**To:** Charlotte Planning, Design & Development

**From:** Doug Lozner

**Date of Review:** September 27, 2021 (***Revised November 22, 2021***)

**Rezoning Petition #:** 21-127

SHEET NO. RZ-100

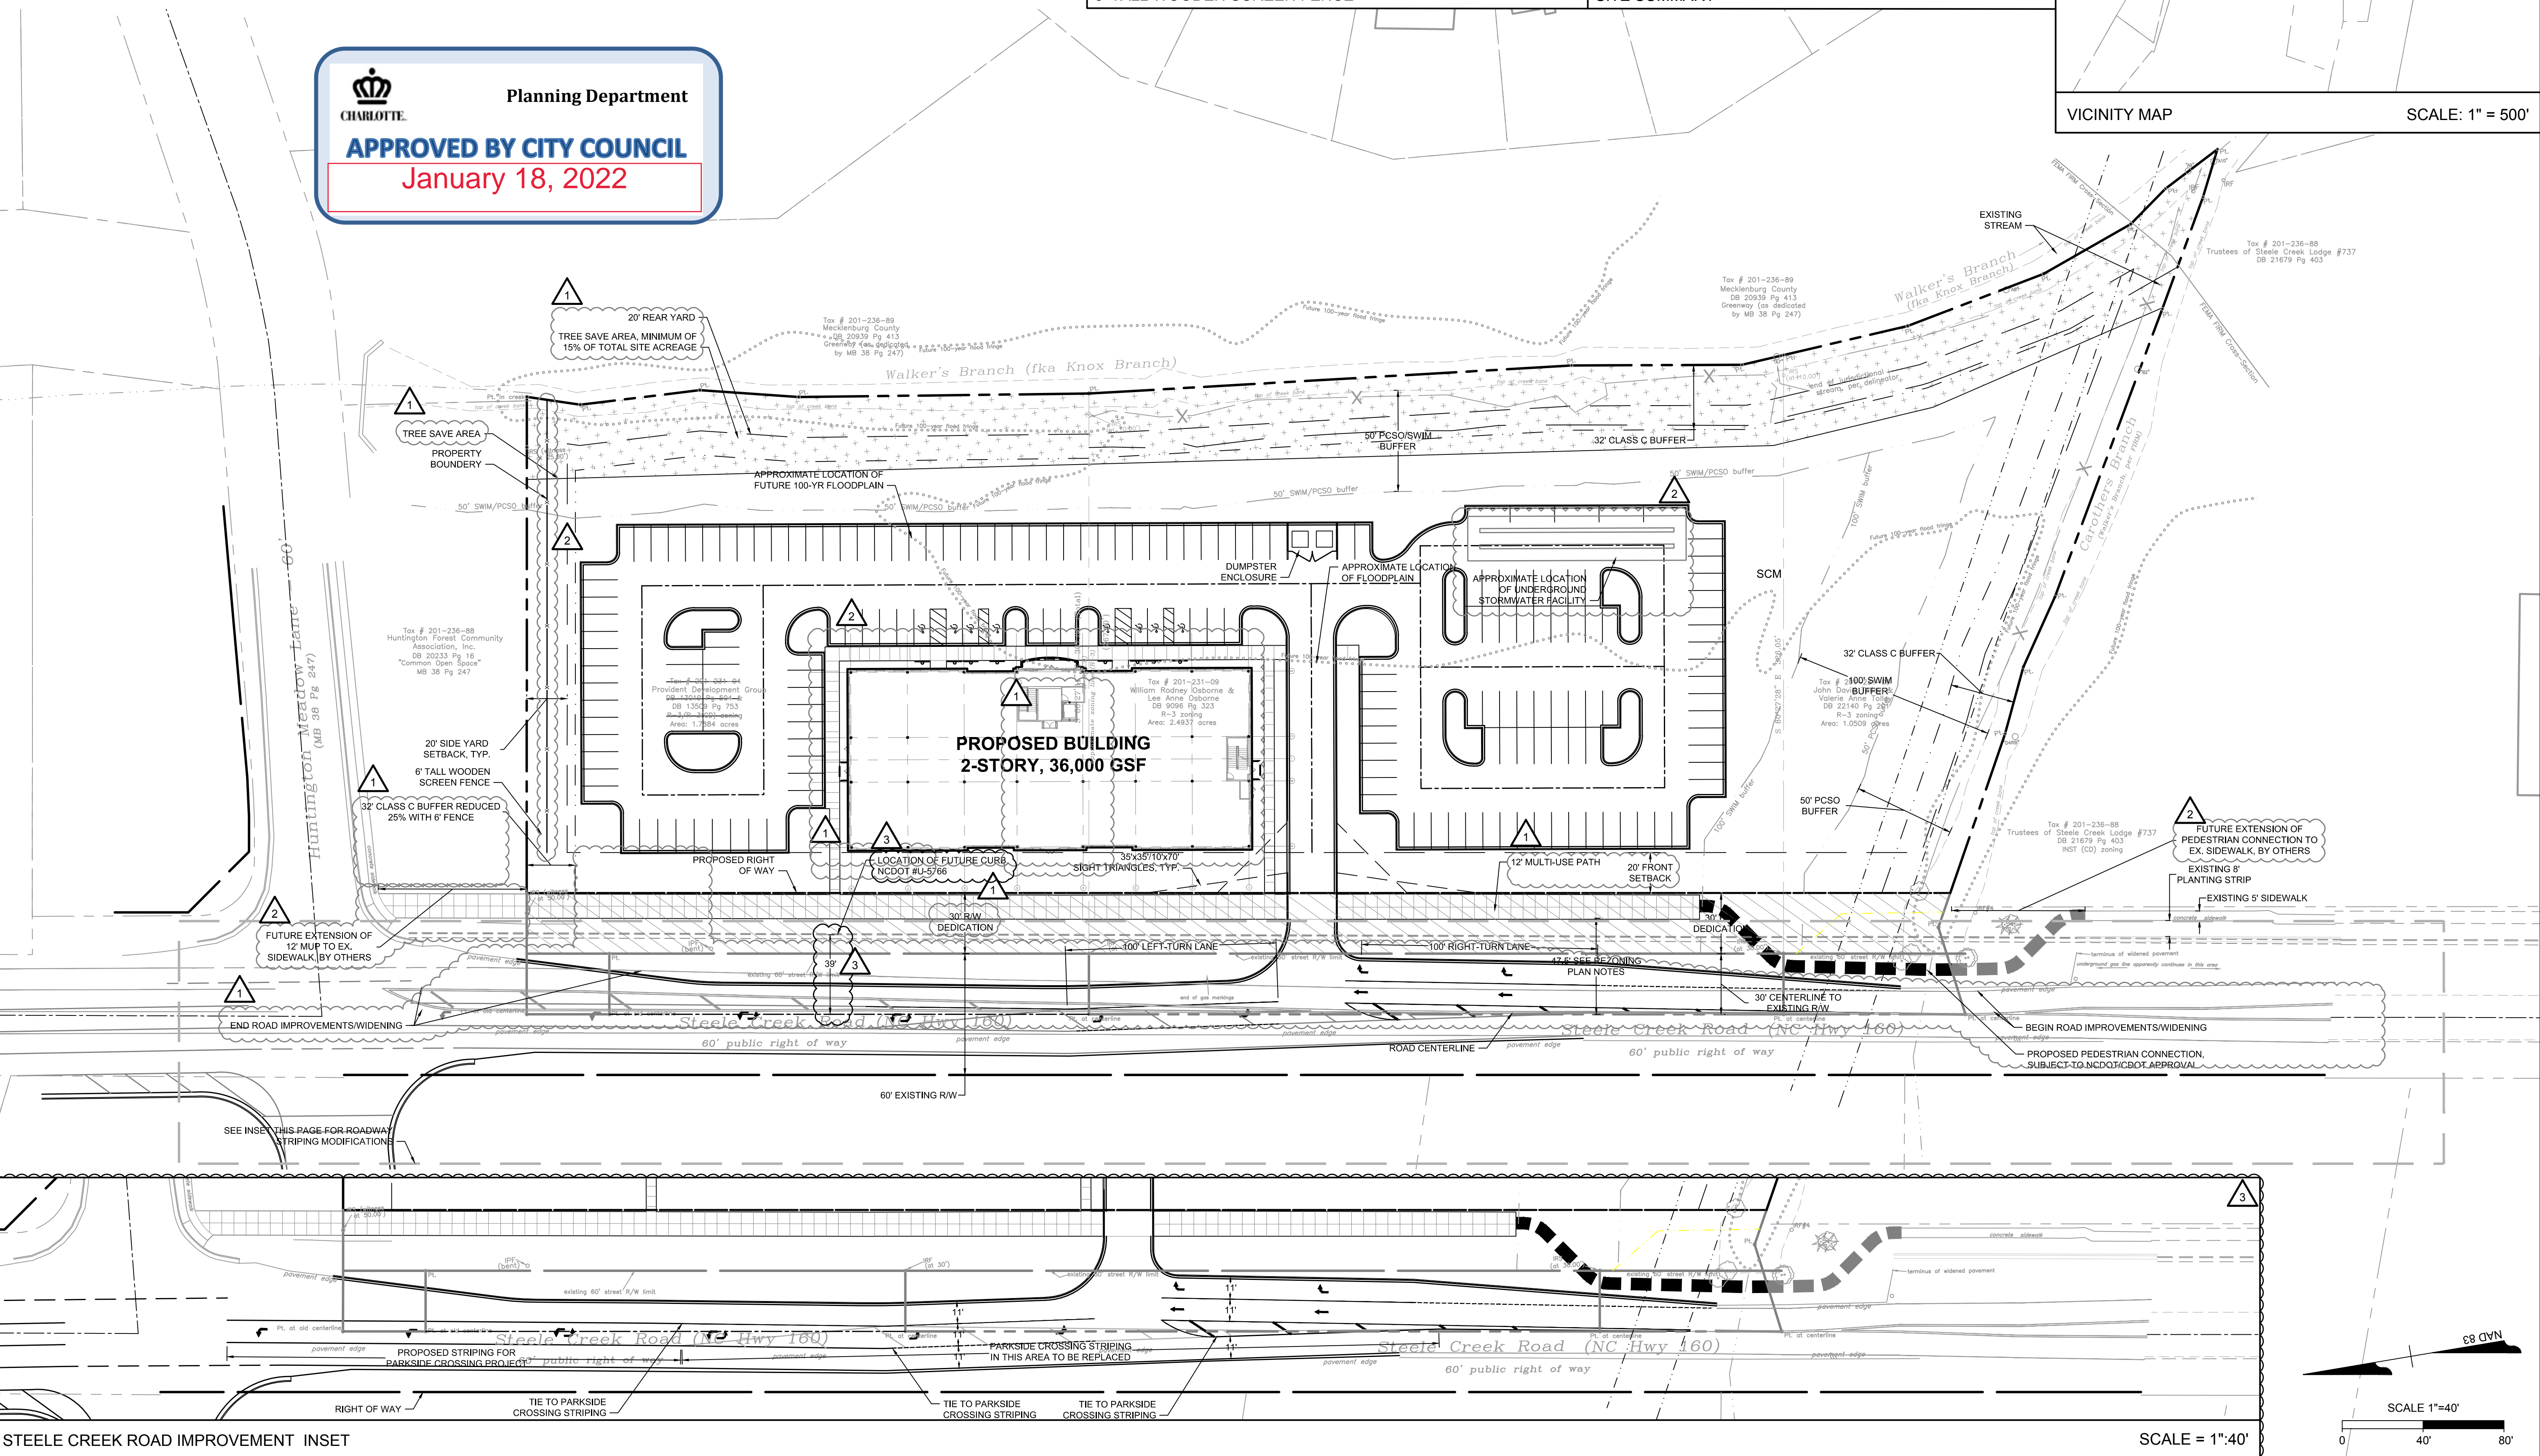
**Recommendations Concerning Storm Water:** The proposed rezoning plan sheet indicates a proposed location for storm water management. Please include the following notes on the plan sheet under "Environmental Features": *The location, size, and type of storm water management systems depicted on the Rezoning Plan are subject to review and approval as part of the full development plan submittal and are not implicitly approved with this rezoning. Adjustments may be necessary in order to accommodate actual storm water treatment requirements and natural site discharge points.*
